**MP\_09\_0153: Dr Chau Chak Wing Building – section 75W application**

Further to our conversation on 20 February, please find attached our Section 75W application for a request to modify a major project.

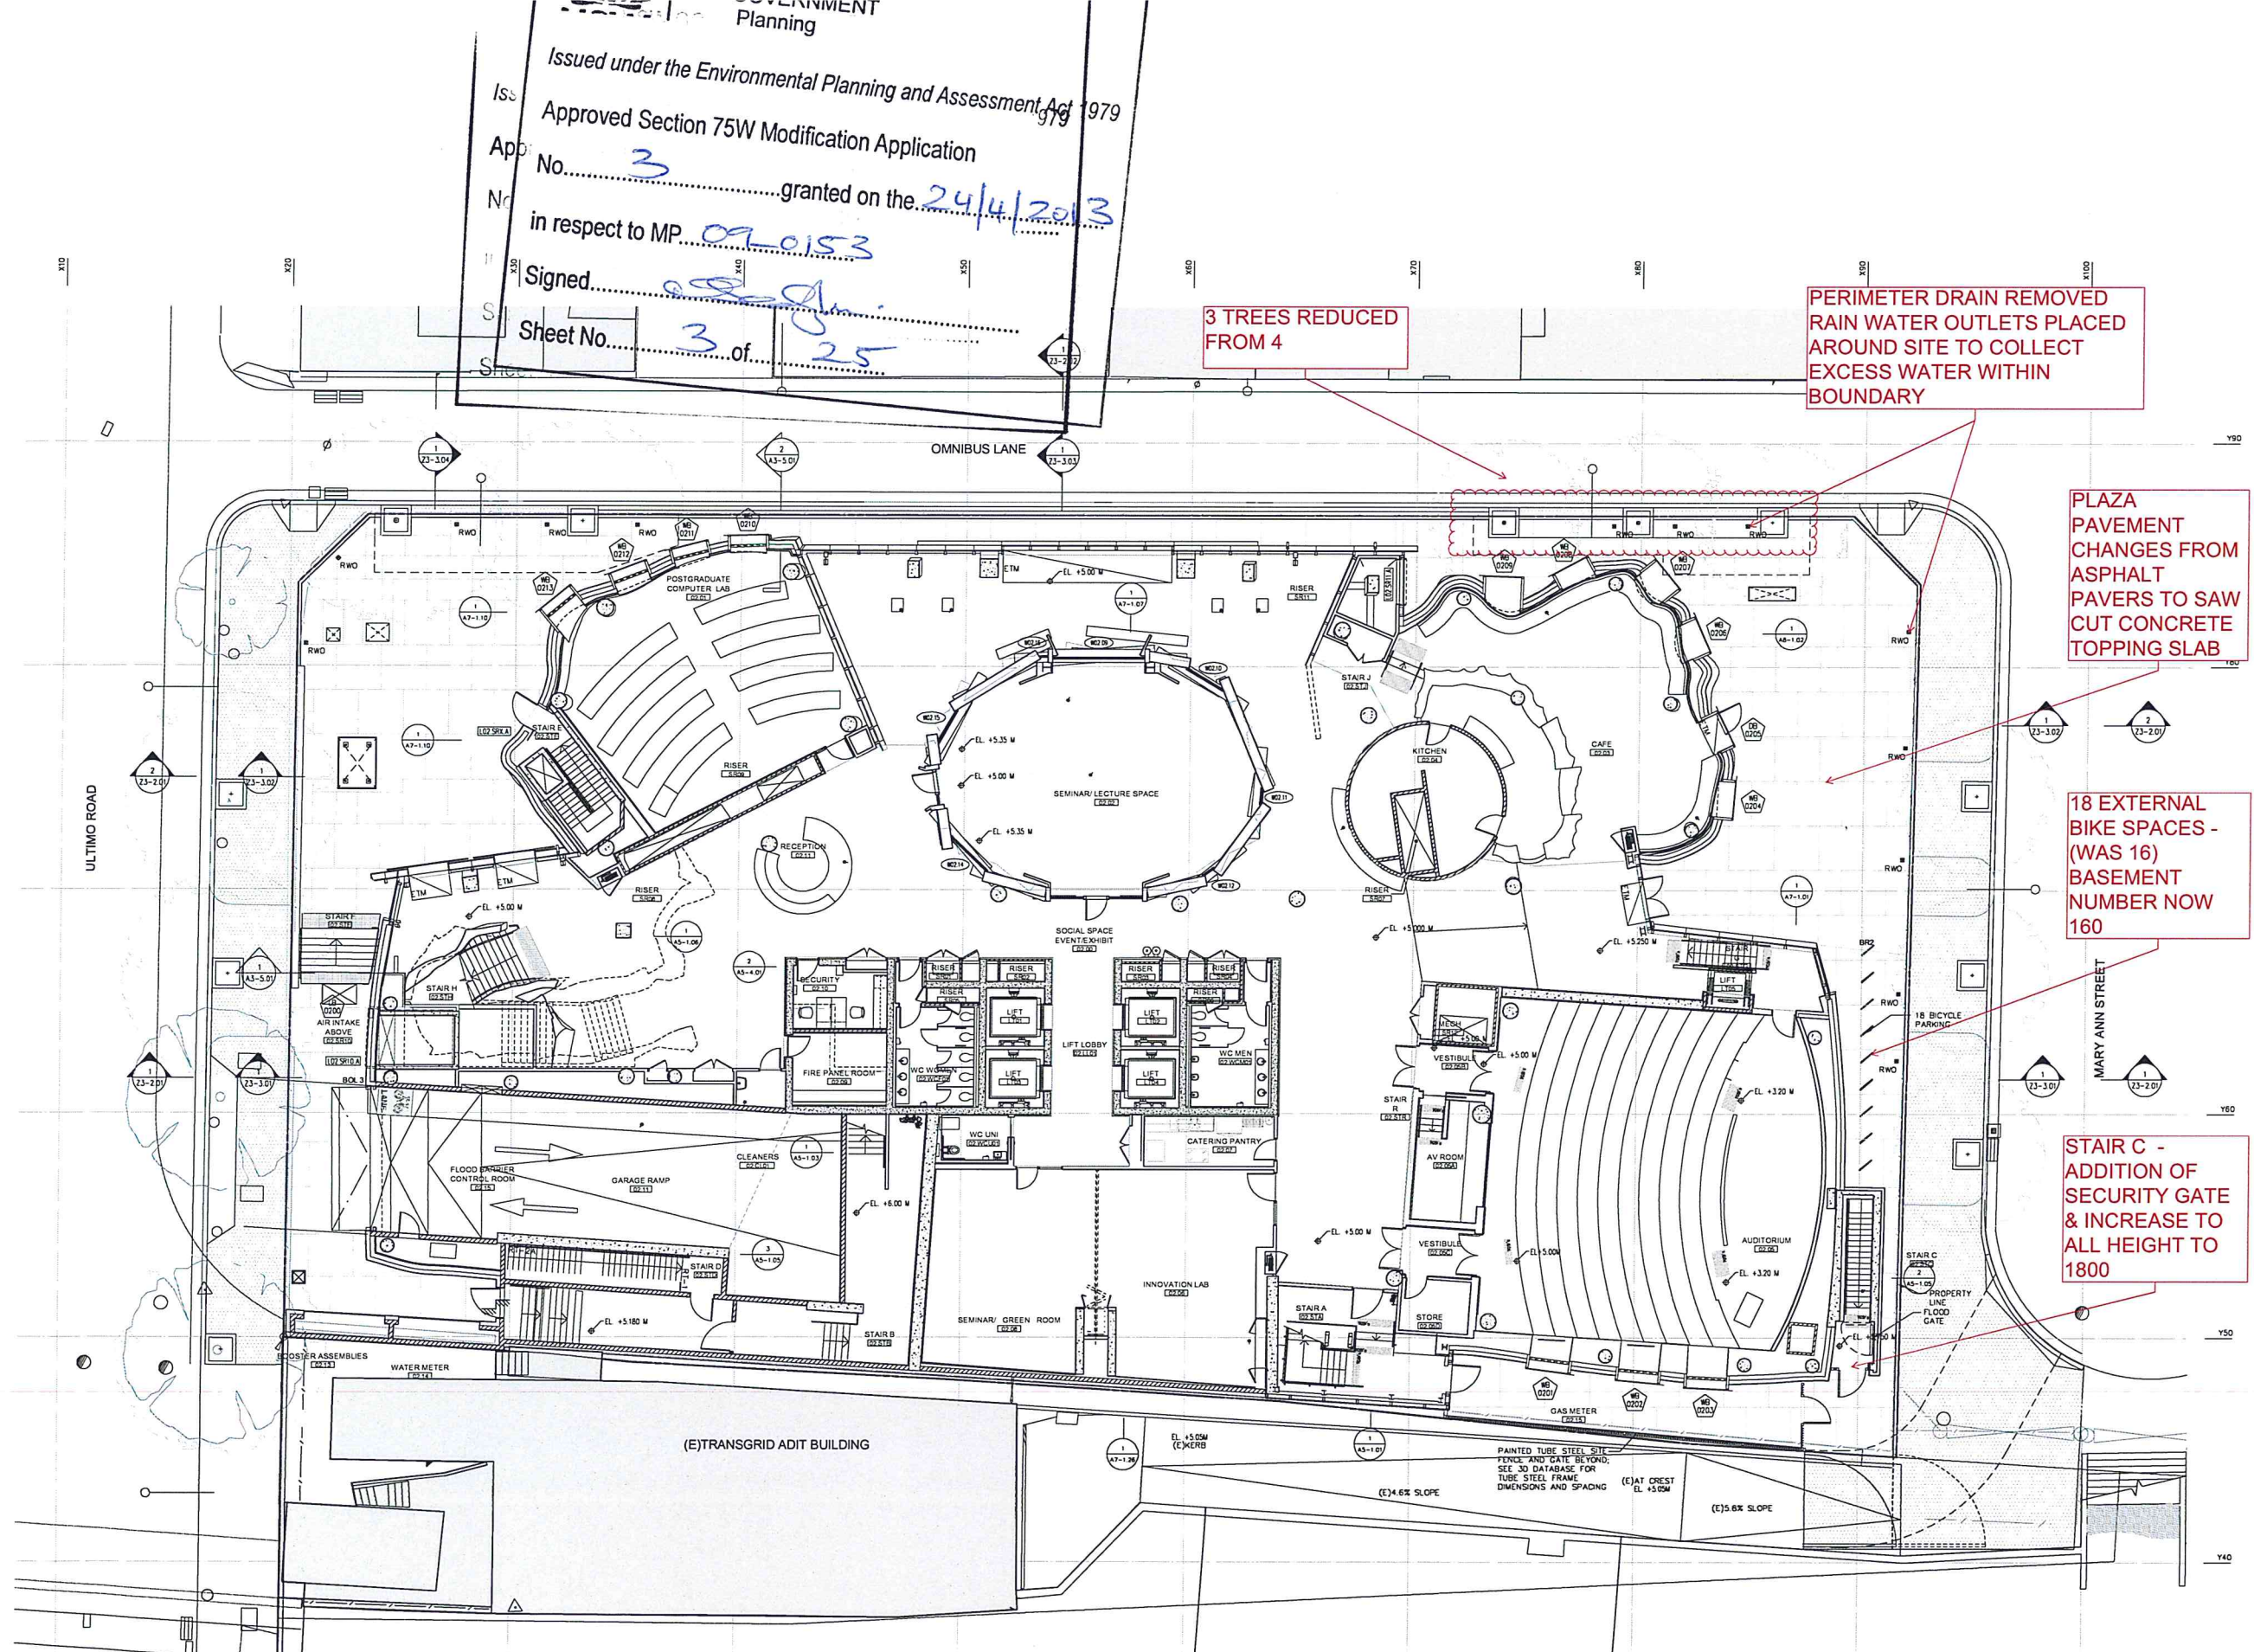
We propose to change the external pavement material from asphaltic concrete to cast in-situ concrete, with saw cut pattern in a natural concrete colour. The originally specified product is an American product and not available in Australia.

The wall height around Stair C has been increased from 1200m to 1800m following a safety in design workshop to eliminate the potential for students to sit on the wall and subsequently fall backwards. A security gate has also been added at the top of the stair well to prevent loitering by enclosing the space to provide a safer urban environment.

The external bike spaces have reduced from 22 to 18 spaces.

The basement bike spaces have increased from 159 to 160 spaces.

Re-design of drainage system following a safety in design workshop due to the potential blockages and trip hazard with the strip drain as designed.

Rain water outlets have been placed around the site in lieu of the strip drain to collect stormwater within the boundary.

To comply with City of Sydney requirements, the trees at the northern end of Omnibus Lane have reduced from 4 to 3 and the spacing between them increased to the Council recommended 6 metres.

PROJECT
2009-022
SCALE
1:100
DRAWN BY
DATE
20-02-2013
SHEET NUMBER
Z2-2.14
© GEHRY PARTNERS, LLP

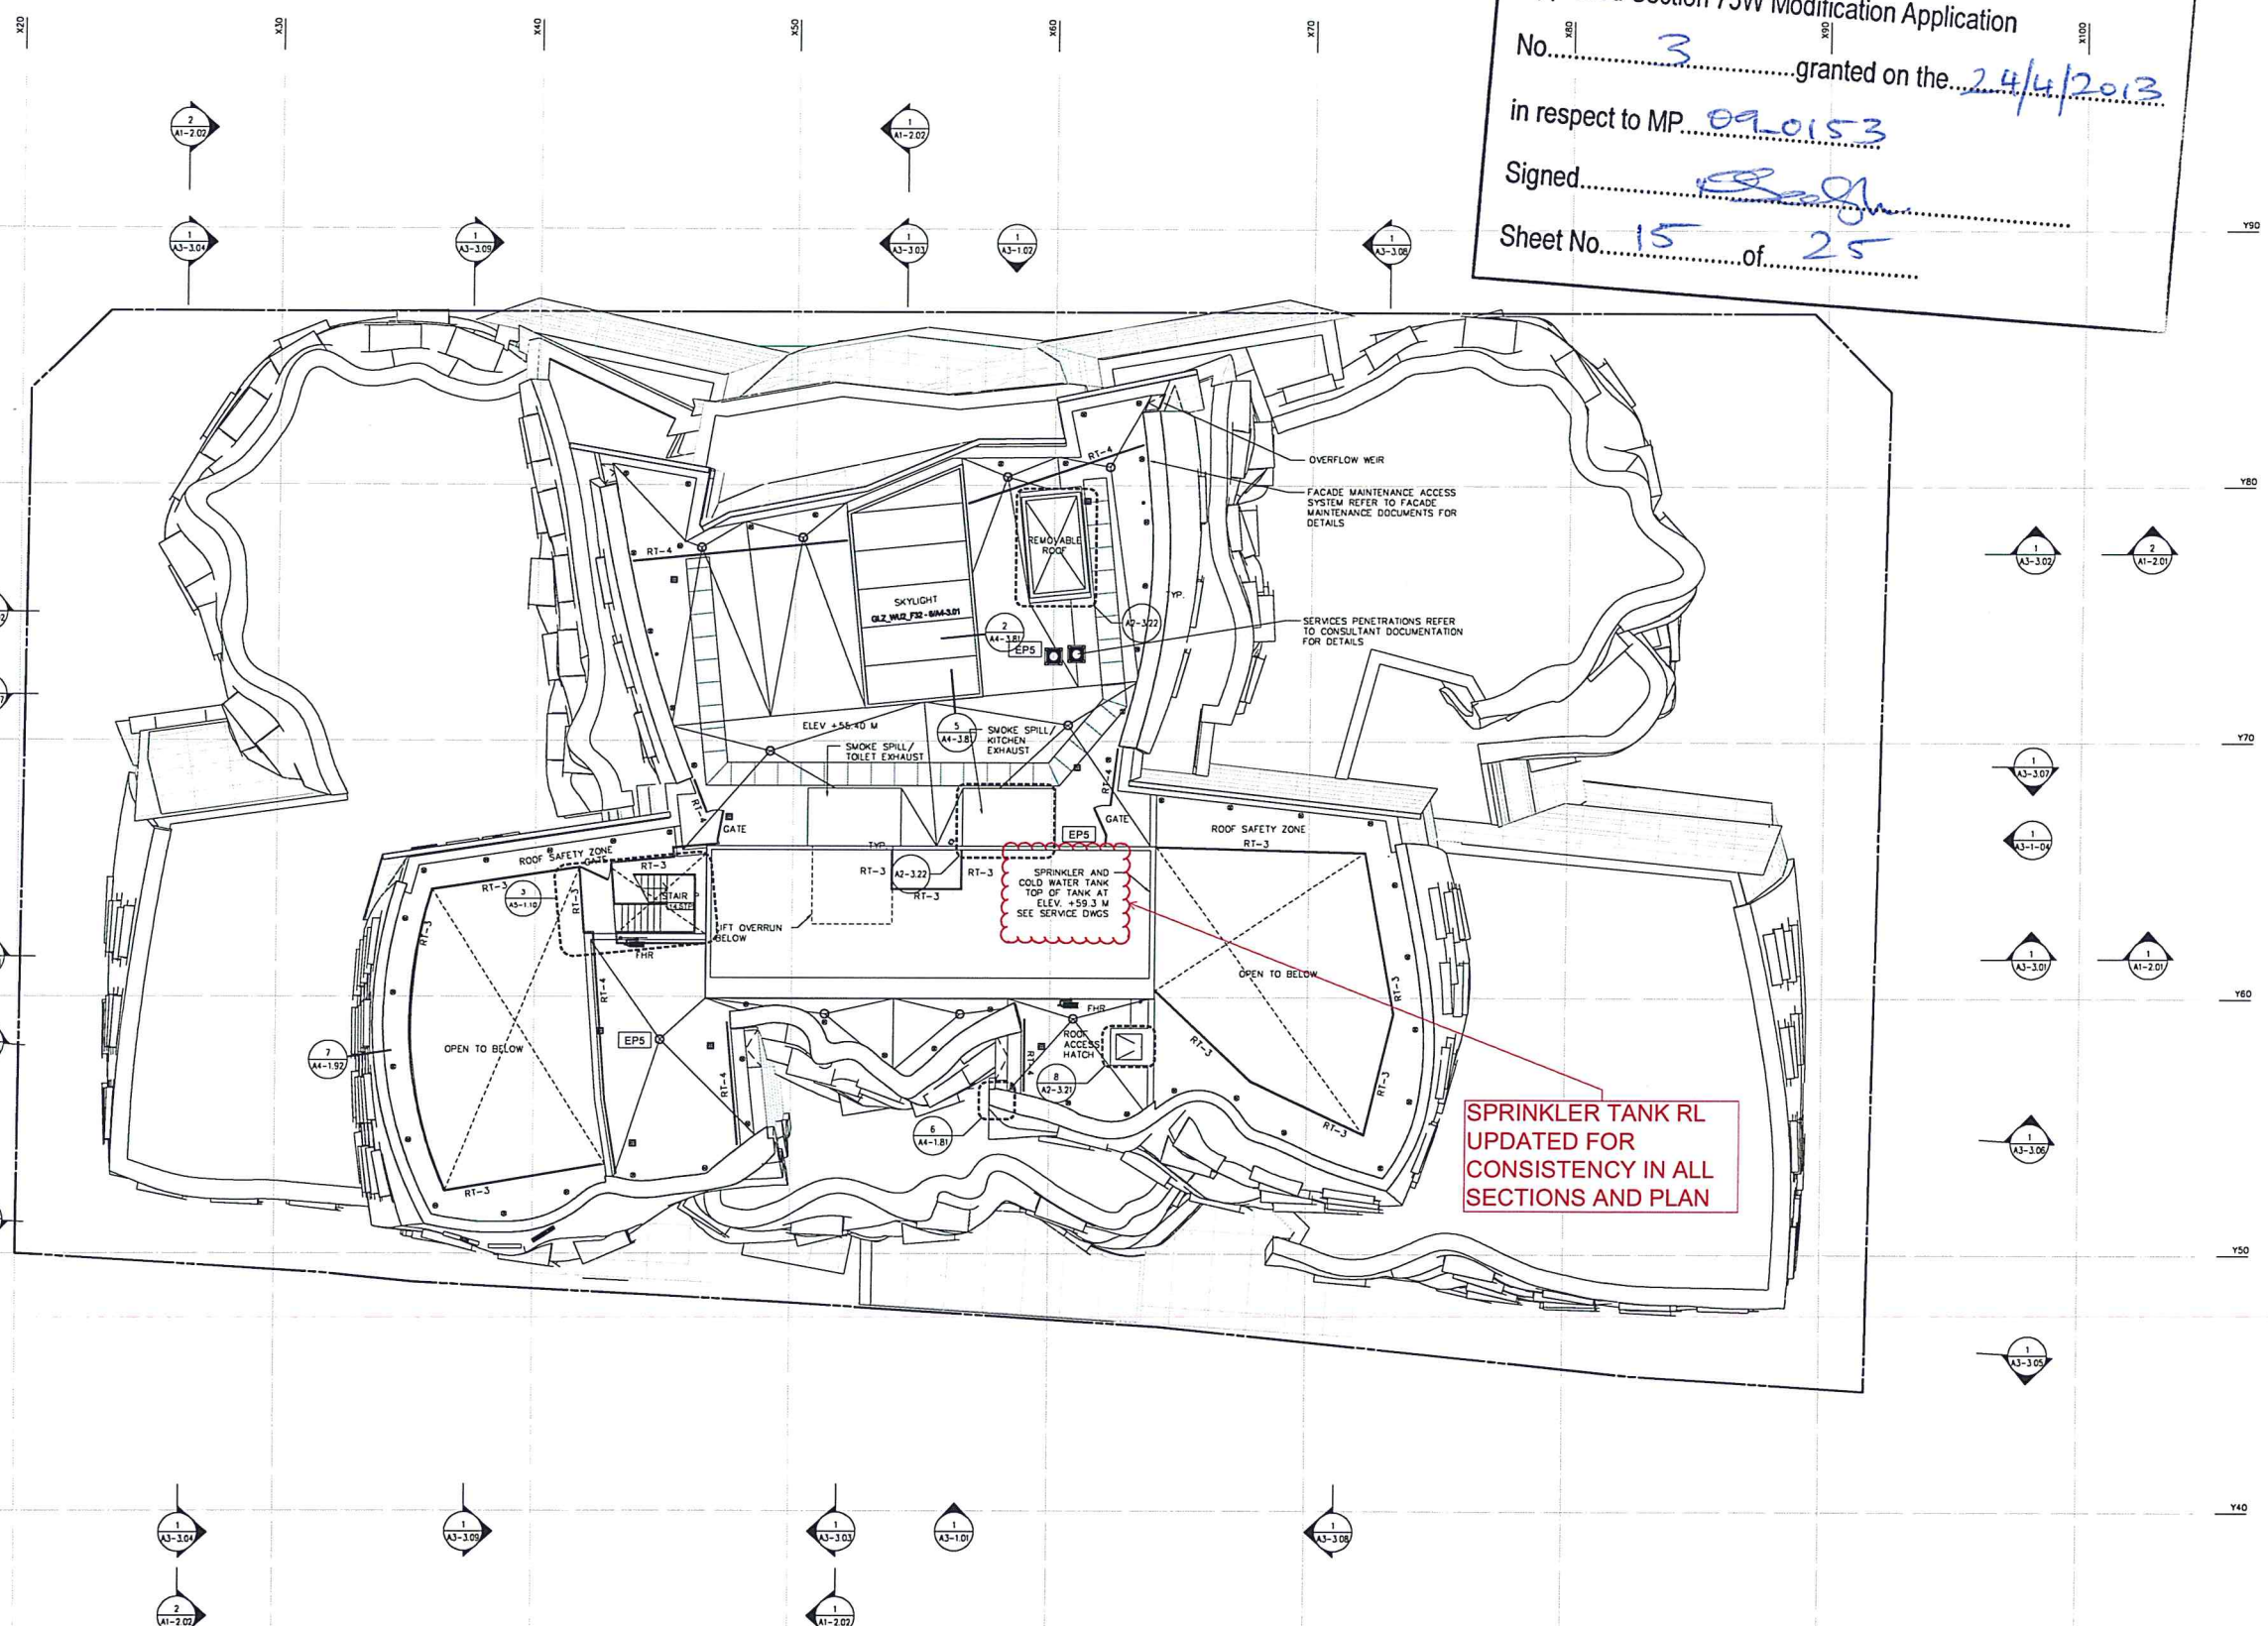
The alternate mechanical design solution following a Value Engineering process is the replacement of cooling tower and triggen plant with air cooled chillers. The plant room roof plan has been changed to reflect the new mechanical system in place. This modification was pursued as the triggen system proposed for the existing scheme was too small to extract maximum efficiency from the technology and was considered more sustainable to connect to a city wide system when available.
